Light Valley Solar

Written Summary of Applicant's Oral Submissions

Issue Specific Hearing 1

Document Reference: EN0110012/APP/LVS/08.08

Project Name
Light Valley Solar

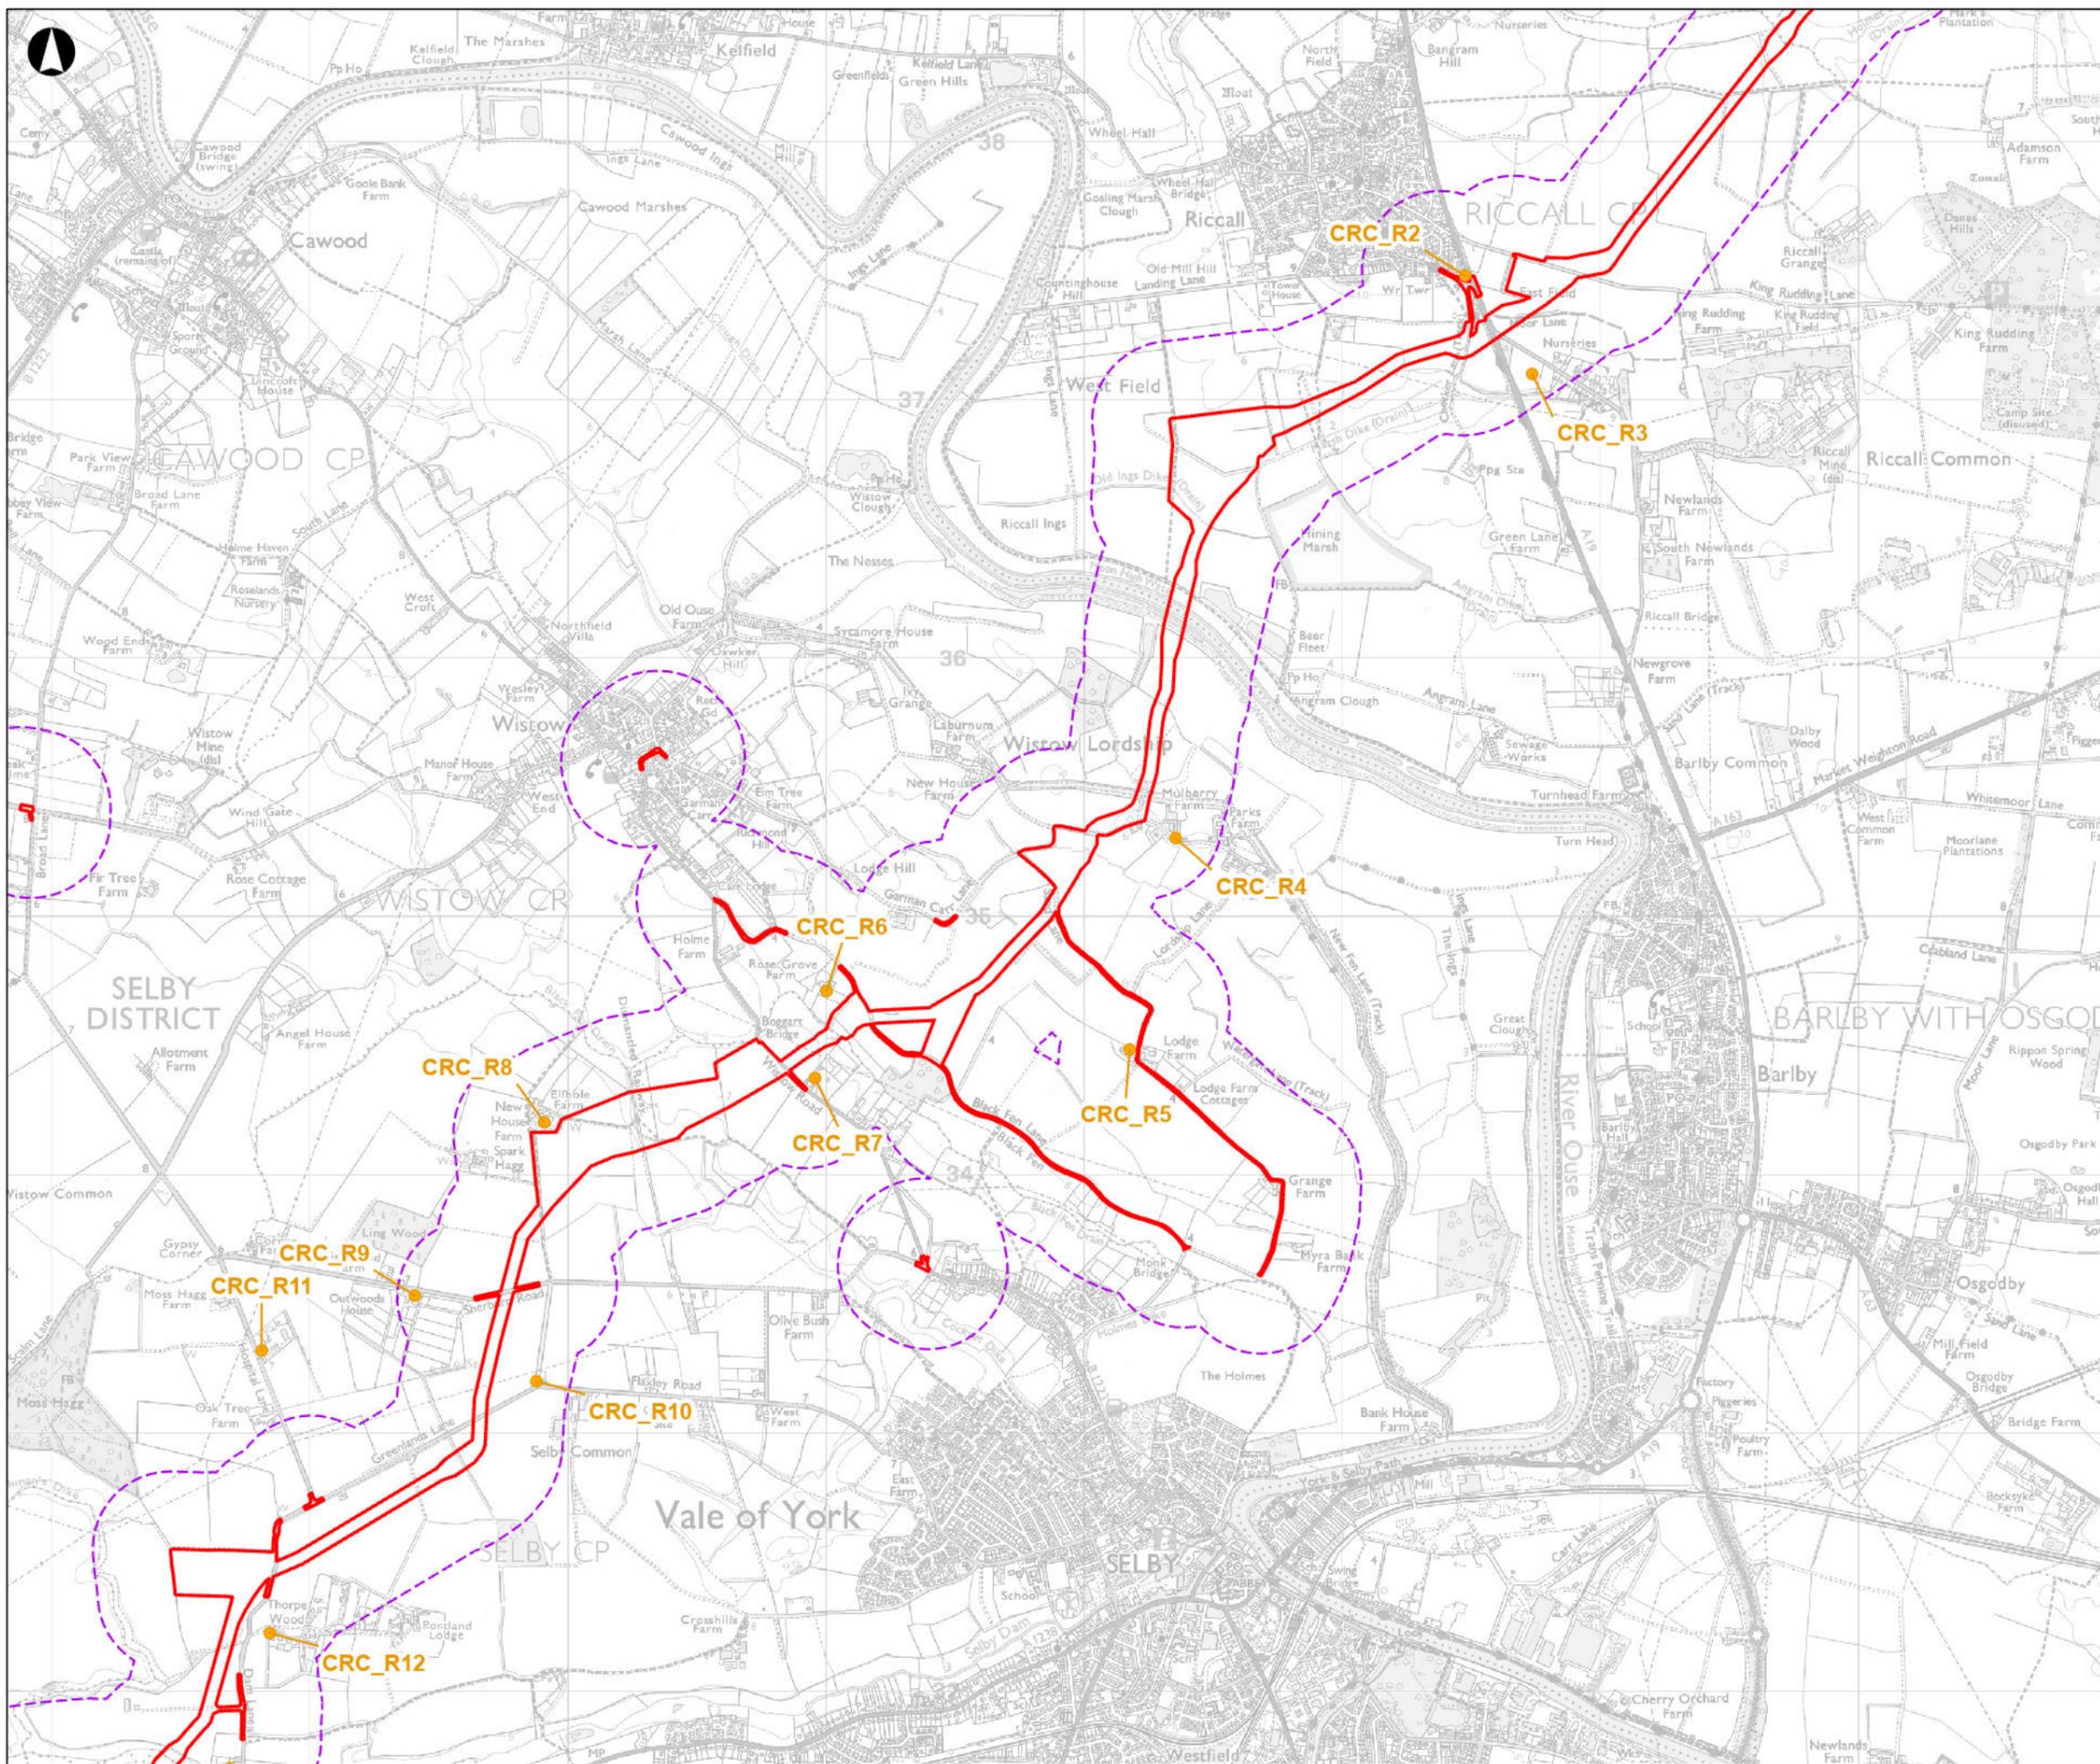
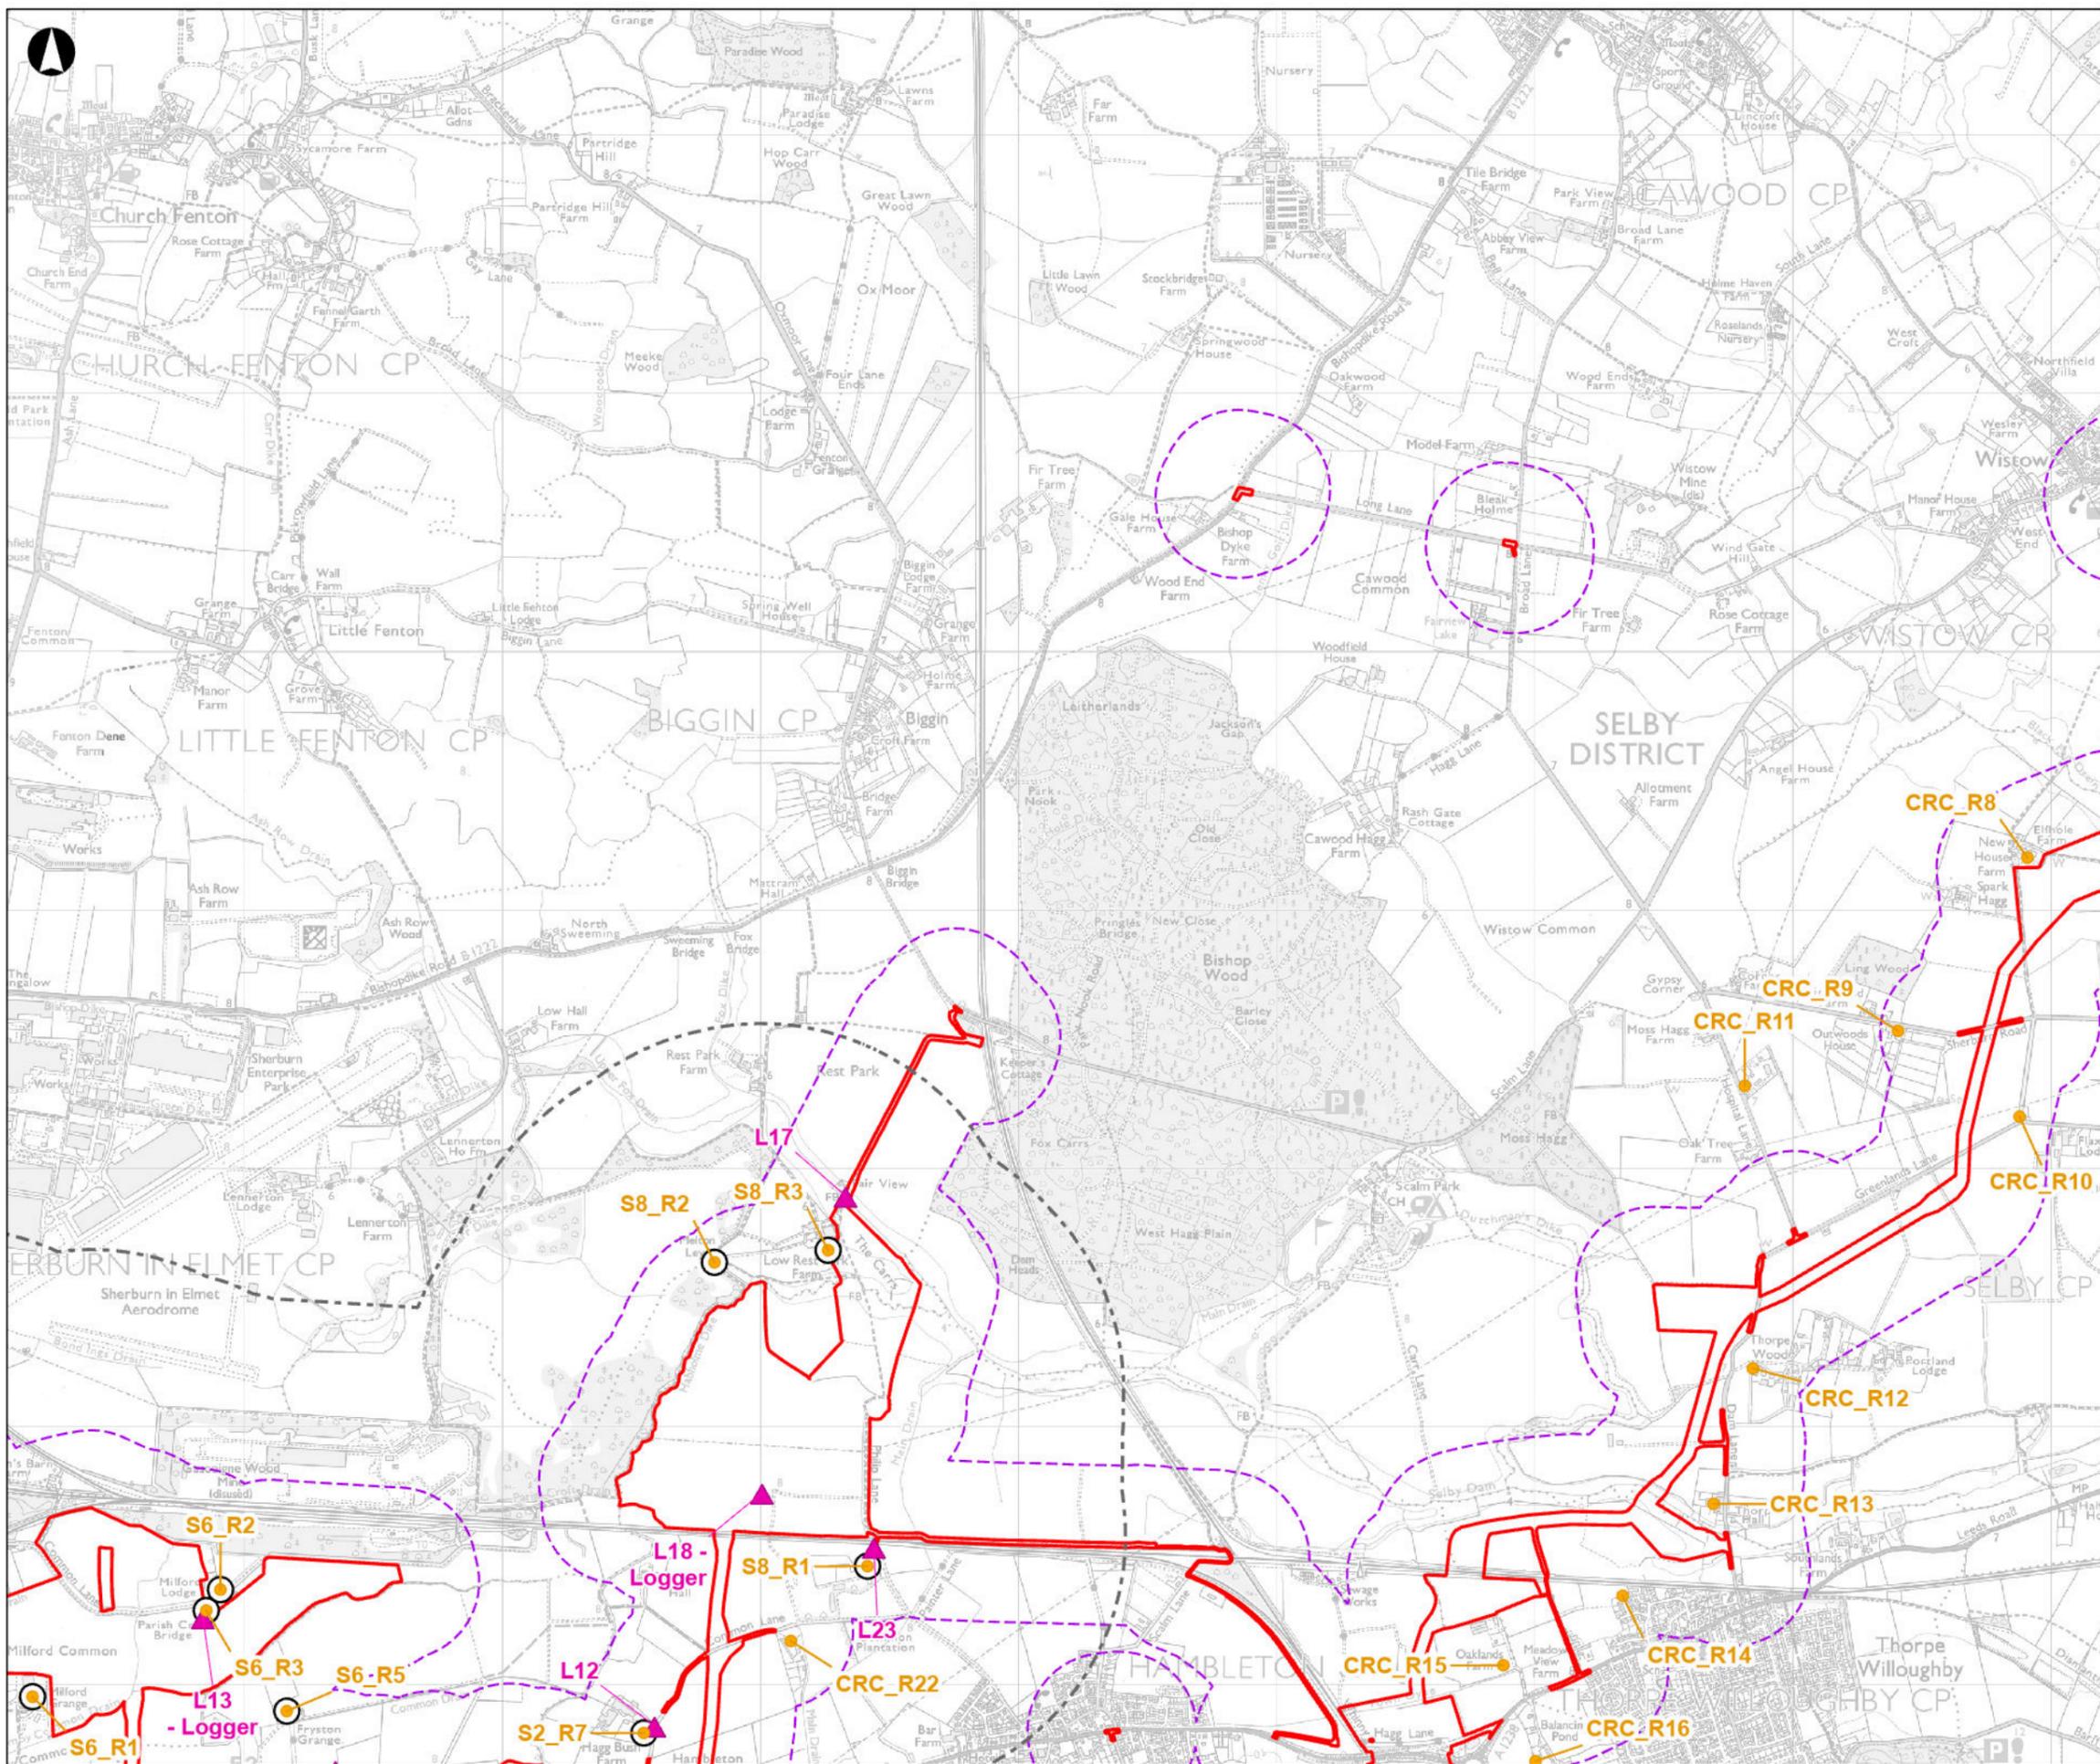
#	Agent Item	Written Summary of the Applicant's Oral Submissions
		<u>Tonality</u> The ExA asked the Applicant to explain the following: ▪ How residential receptors have been assessed with reference to Appendix 11.3 [APP-173]; ▪ How the characteristics of tonality, intermittency, and impulsiveness have been considered within the assessment; ▪ Whether those characteristics could materially alter the perceived impact on nearby receptors; and ▪ How the applicant proposes to introduce future controls on operational noise at residential receptors. <u>Assessment methodology</u> In respect of the sound level, Mr Hiller confirmed that 91dB mentioned at the Open Floor Hearing is from Table 2.1 of ES Appendix 11.3 [APP-173] and this is a sound <u>power</u> level. The Applicant explained that sound power levels characterise the output of a source. Those levels are inputted into three-dimensional noise mapping software which then predicts the sound levels arising from the site at all assessed receptors. These calculations are then interrogated to show the likely noise <u>impacts</u>. Mr Hiller confirmed that the assessment of operational noise has been carried out in accordance with British Standard 4142 (Methods for rating and assessing industrial and commercial sound), which is the appropriate standard for noise sources of a commercial or industrial character. This is applied to building services plant and associated equipment. He submitted that this standard is equally applicable to the sources proposed in the Proposed Development. The approach involves comparing the predicted noise from the plant against the background sound level at each receptor, assessed separately for daytime and night-time conditions. Baseline sound levels have been established from an environmental sound survey using noise loggers deployed at

#	Agent Item	Written Summary of the Applicant's Oral Submissions
		various locations, illustrated in Figure 11.2 of the Environmental Statement [APP-099]. The tabulated impact assessments following the BS 4142 methodology are set out in ES Appendix 11.3 [APP-173]. Mr Hiller confirmed that the Applicant had assumed a 4 dB correction (tonality penalty) for the predicted sound levels from all assessed equipment. This penalty is taken from British Standard 4142 and is representative of what the standard describes as "clearly perceptible tonality" in the sound as perceived at the receptor. Intermittency in this aspect would not be relevant as the equipment will operate in a continuous manner whilst running, rather than switching rapidly on and off over short time periods. Accordingly, an intermittency correction has not been applied. Moreover, Mr Hiller explained that tonality affects people's perception of sound without necessarily producing a higher absolute noise level. By applying the tonality penalty when calculating the rating level, the assessment produces a more representative evaluation of the impact on people's perception of the noise, rather than relying solely on the raw sound level. The Applicant did not identify impulsiveness as a characteristic applicable to the operational noise sources in this development. No impulsiveness correction has been applied. <u>Future controls on Operational Noise</u> The applicant acknowledged that the level of control that can be applied to tonality cannot be fully assessed until the individual items of plant are understood in detail. For the purposes of the assessment, it has been assumed that tonality may or may not be perceptible at receptors. There are a number of sources for each of those so tonalities may or may not be perceptible as the noise from the sources may attenuate to the point where it is inaudible against the background soundscape. Mr Hiller noted that, for example attenuators could be fitted onto conversion units to reduce sound levels where needed. These can be used to control frequency content if necessary. Moreover, it has
